Your Ref: 000013958
Our Ref: BR/244/12/
Please ask for:
Miss K Rawlins

31st October 2012

Erection of rear conservatory, erection of new front & side fence & alterations
23 Devonshire Road Bognor Regis

Planning Approved  
French Doors  
Front Fencing  
AND CANOPY OVER EXISTING  
OPENING

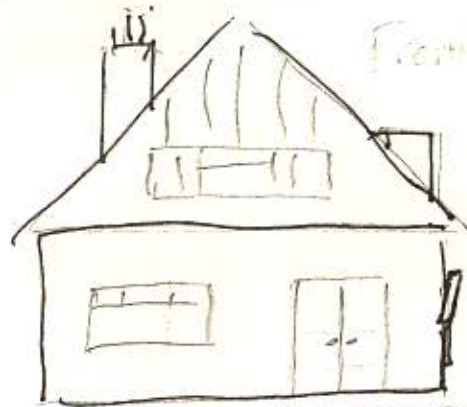
NO OBJECTION. But concern raised over the height of the fence intended (dimensions have not been supplied). The committee commented on the impact this fence may have on the street scene.
